We acknowledge the comments made by the Applicant in the document 'The Applicants' Responses to Relevant Representations' (Application Reference 10.3) in response to our submitted Relevant Representations. We can confirm that whilst discussions on reaching a voluntary agreement have continued since we made that submission, a binding agreement on the land has not been completed. We continue to object therefore to the Proposed Development. If the Applicant's assurances and proposed mitigations become legally binding we may then be in a position to withdraw our application. Our Relevant Representation is resubmitted as an attachment to this Written Representation.

Relevant Representation (Objection) on behalf of Albanwise Limited regarding:

Proposed Dogger Bank South Offshore Wind Farms (the “Projects”)

Proposed Dogger Bank South Offshore Wind Farms Order (the “Order”)

DRAWING NUMBER: **005028746-01** PAGE NUMBER: **18 of 20**
 Application Reference: 2 / APPP Regulations: SC(10)

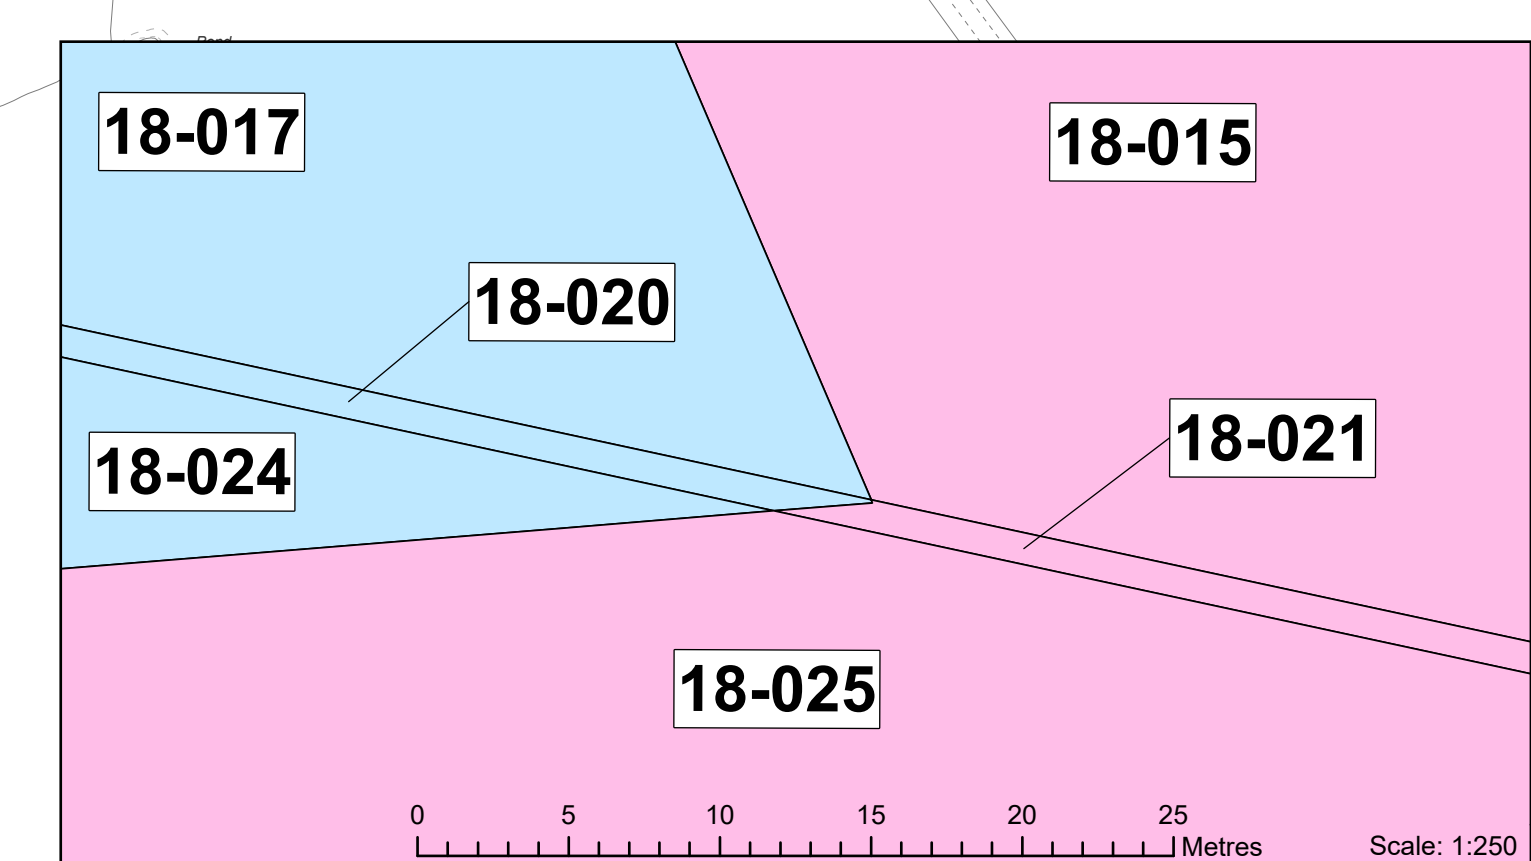
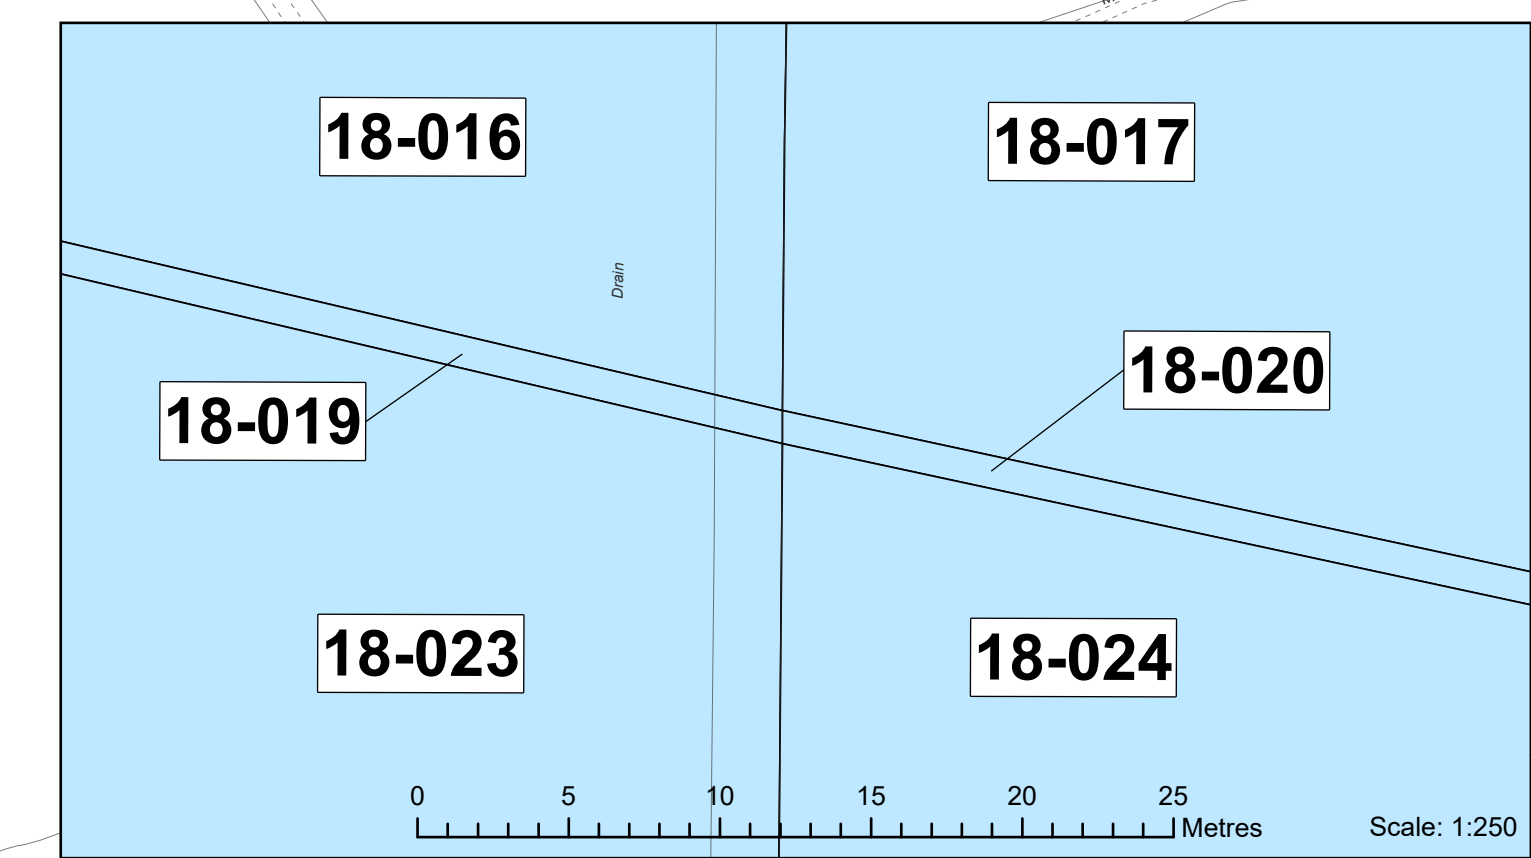
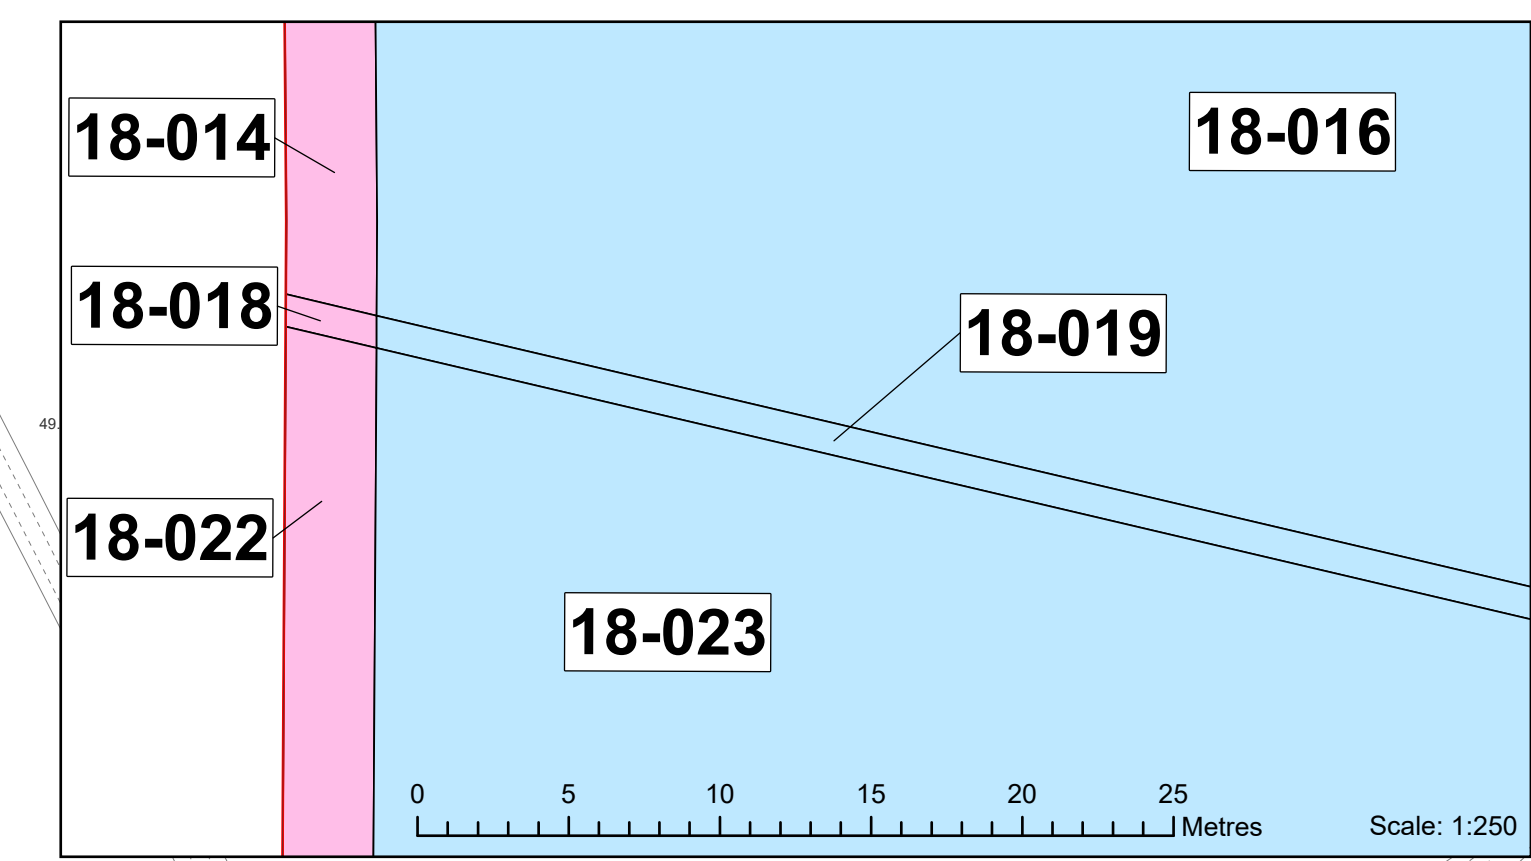
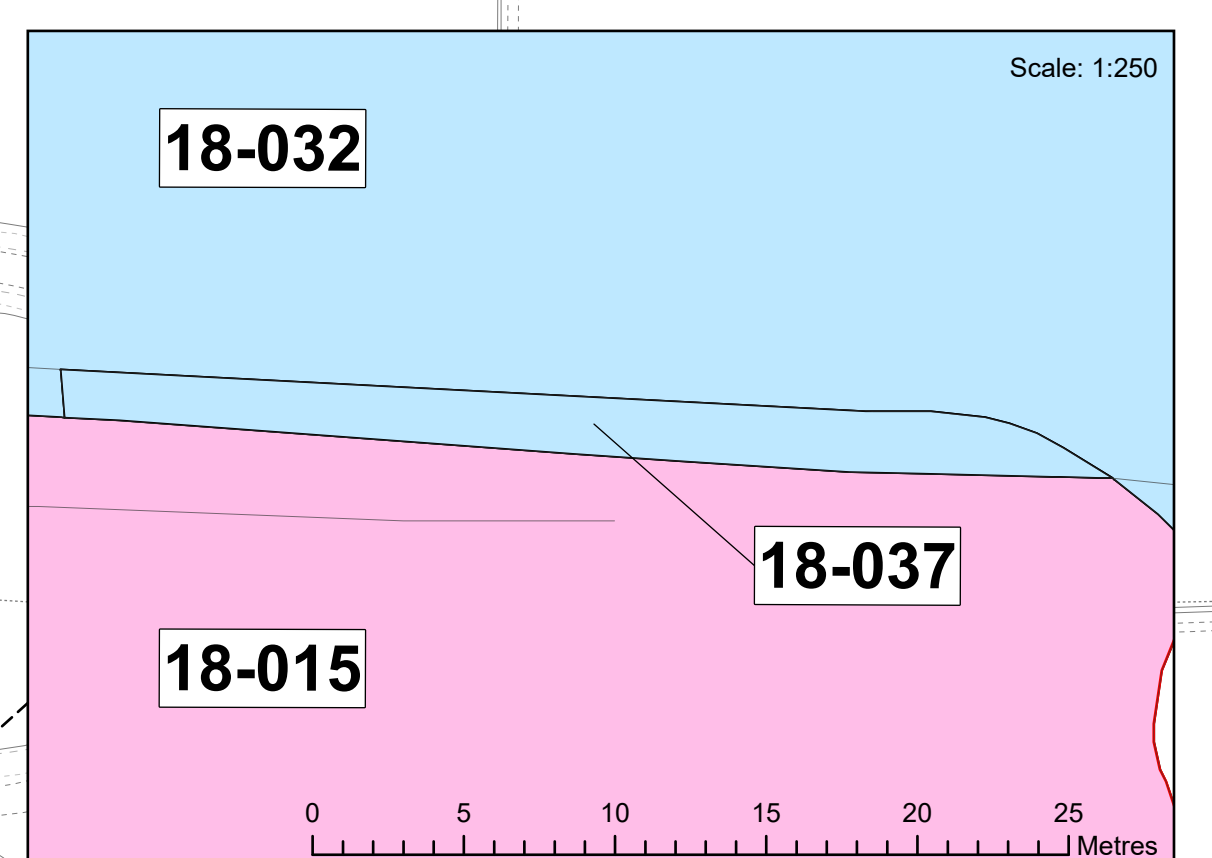
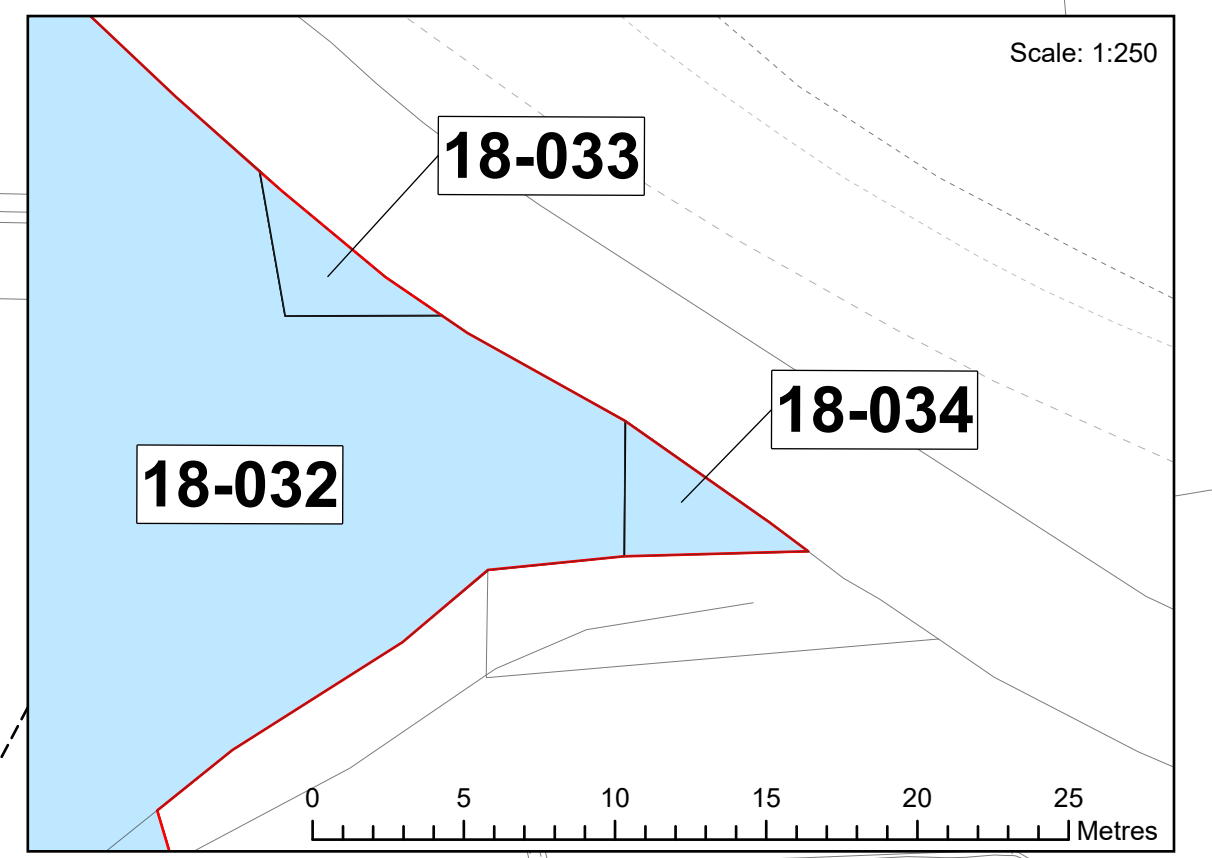
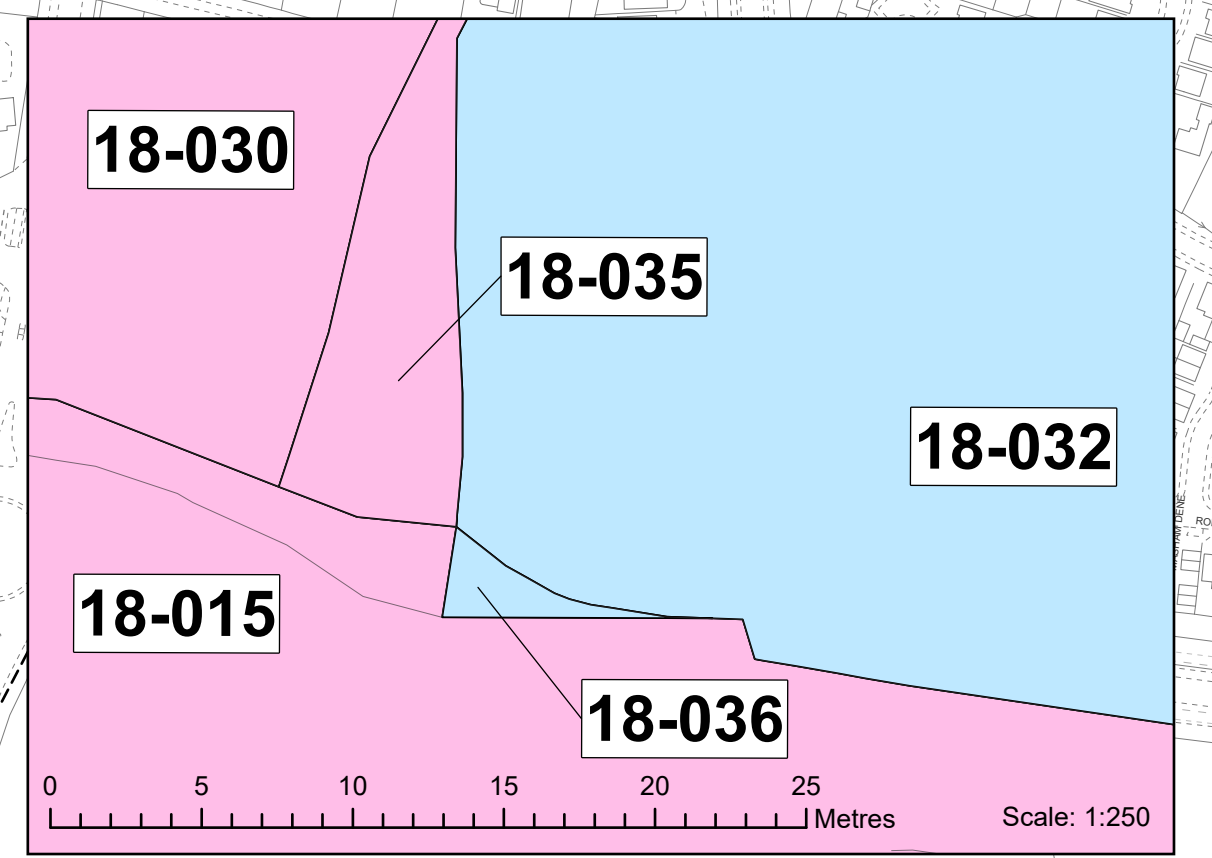
- a. the splitting of the cable route (Works no 32B) across twin paths, involving (but not limited to) land plots 18-054, 18-052, 19-003 and 19-007. Separating the cables by such a distance greatly increases the overall extents of the impact in the land and diminishes the prospects for further utilization of the land for any business interest of AWEL;
